# CITY OF ALBUQUERQUE

PLANNING DEPARTMENT – Development & Building Services

RE: New Day Expansion – Conceptual Grading & Drainage Plan  
2820 Ridgecrest S.E. No PE Stamp (Imprinted 9/24/12) ~ File: **M18-D014**

DRAWN BY BJB
REVIEWED BY FCA
DATE
PROJECT NO. 11-0116
DRAWING NAME
SHEET NO. CG-101

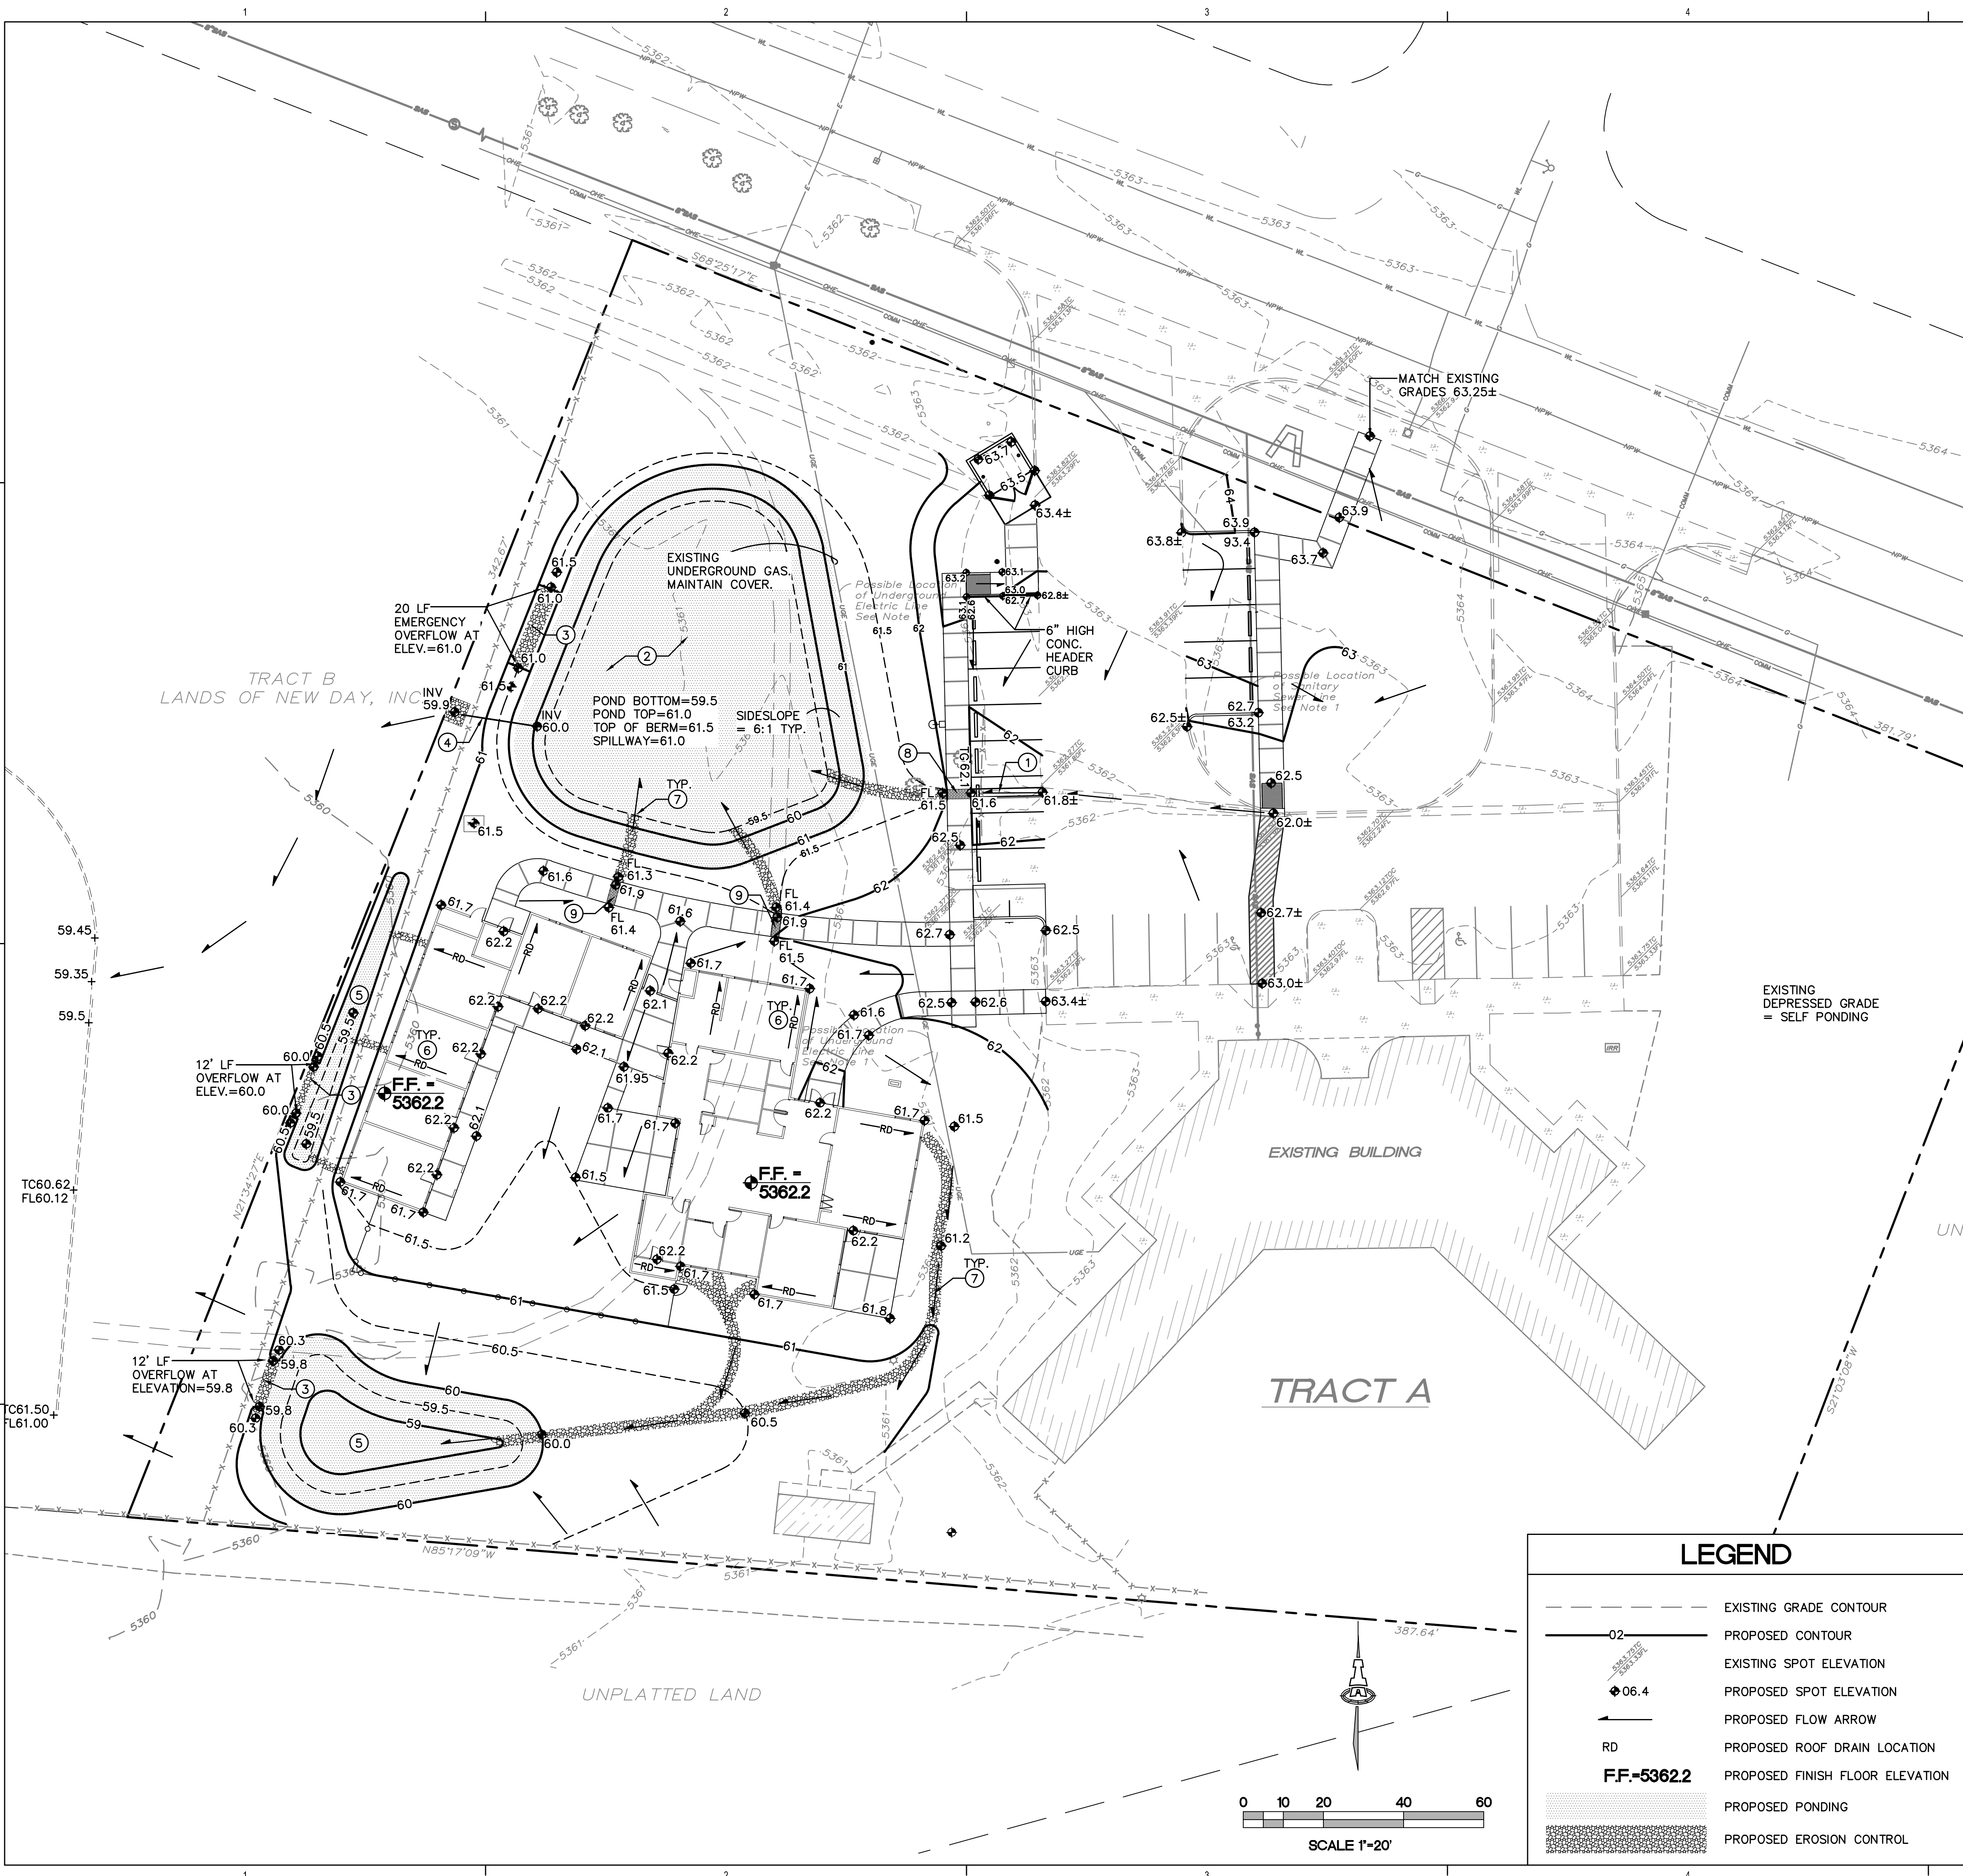
1. Offsite flows appear to enter the site from the east of the existing building, based upon topographic maps and drainage calculations for the original building. This area and flow must be included in the basin map and drainage calculations.

2. The verbiage in the “PROJECT SCOPE” section which refers to a maximum 3.0 cfs runoff is confusing. This appears to be the undeveloped runoff from the original building site only. This plan needs to include the offsite basin area, and compute the allowable maximum as the “undeveloped discharge rate” for this site.

3. Calculations on this plan show undeveloped runoff of 4.7 cfs and 9.2 cfs developed. Final design for Building Permit will need to adequately detain the developed flow at or below the computed historic runoff rate.
